I attach the updated package and would offer my comments in response as below:

Engineers comments on surface water drainage (Conditions 4 & 5);

Subject: D1955: 21-113 Canada Rd & Ellis Cl

HIGHWAY RETAINING WALL  
HOLLOW BLOCK WALL

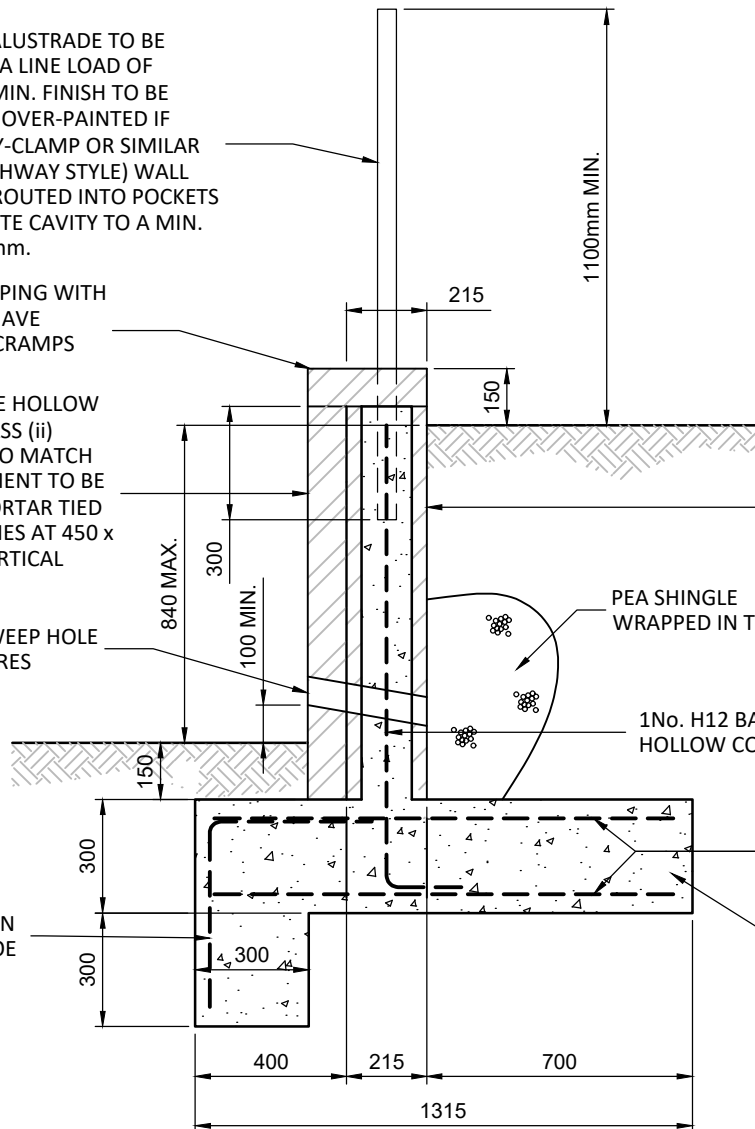
3. Highway retaining walls noted to include weepholes/granular backfill – please update note on plan. Annotation update to coordinate with the WSCC approved data (also enclosed).

TYPICAL CATCHPIT DETAIL (1200Ø)
(Scale 1:20)

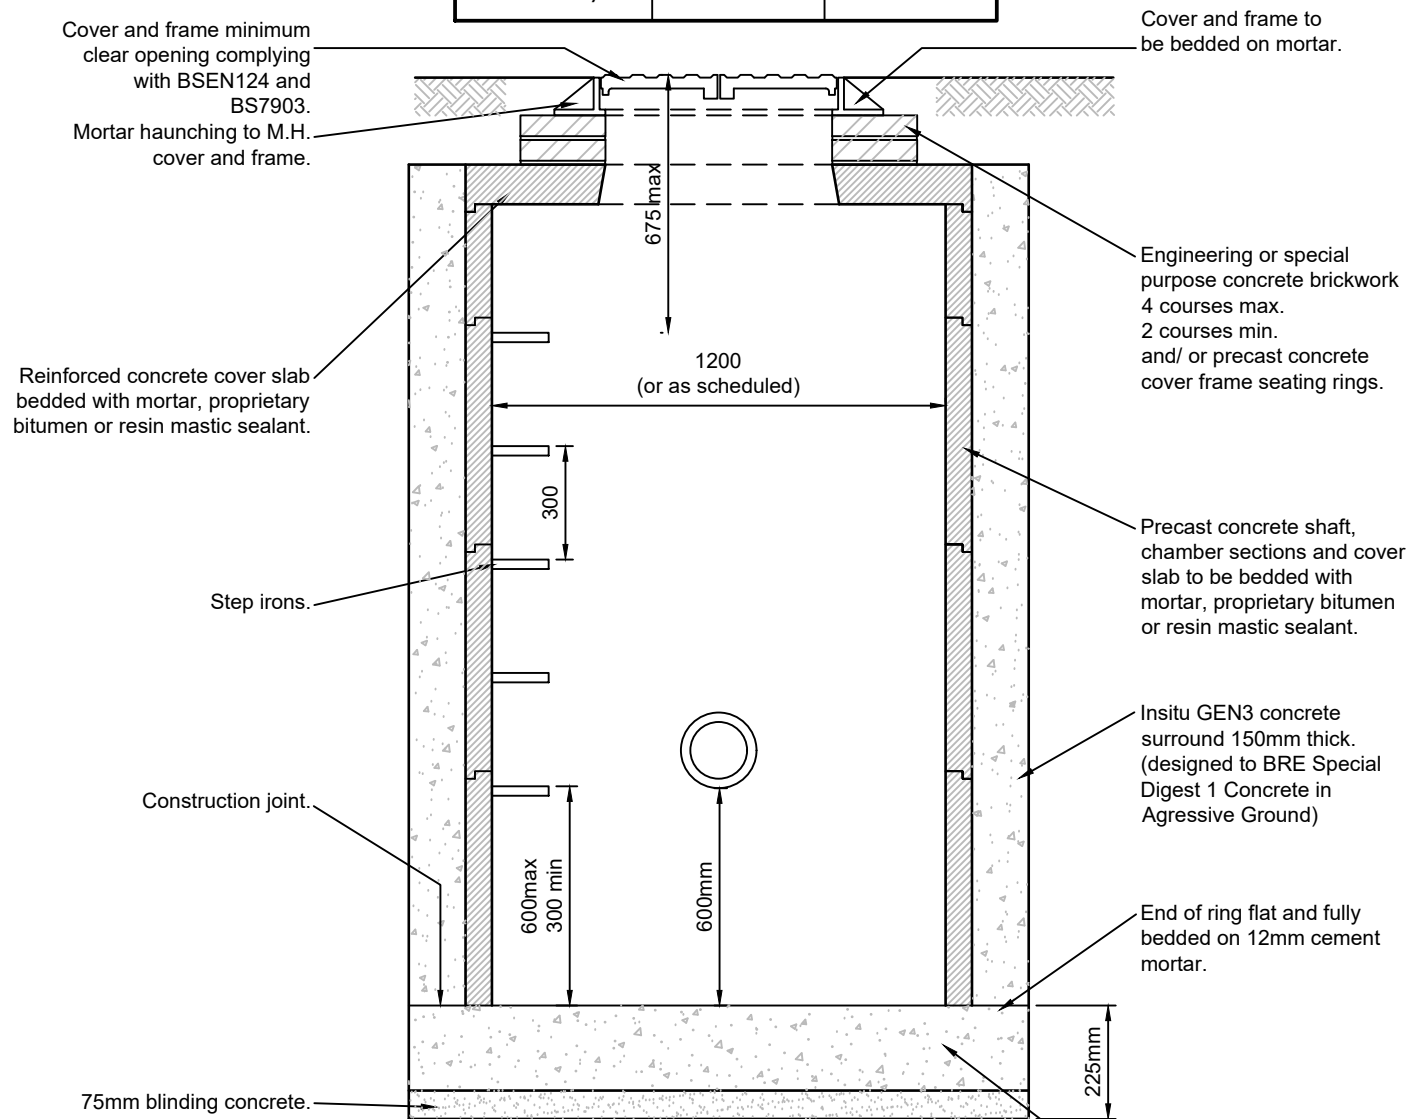
b) Catchpits – specify ductile iron covers & frames of suitable load grading. Noted and updated.

POLYPROPYLENE SHALLOW SILT TRAP DETAIL (500Ø)
(Scale 1:20)

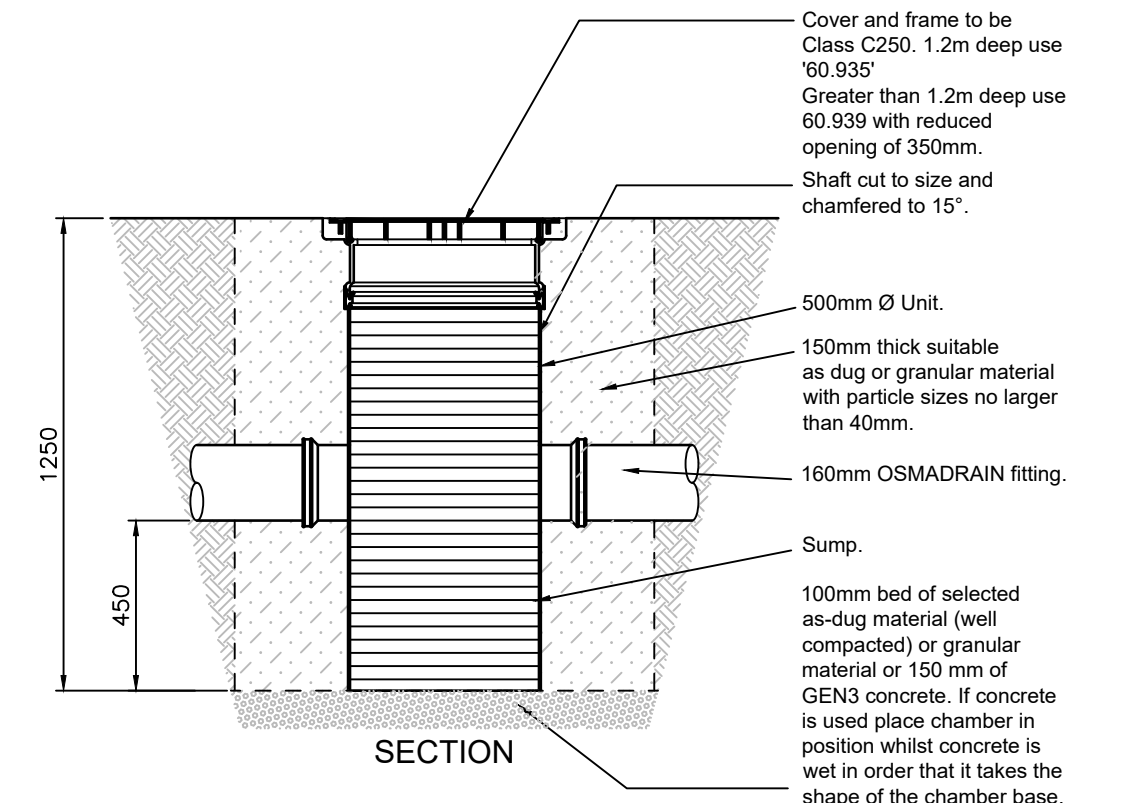
a) Include sump outlet detail for channel drain. Noted and updated.
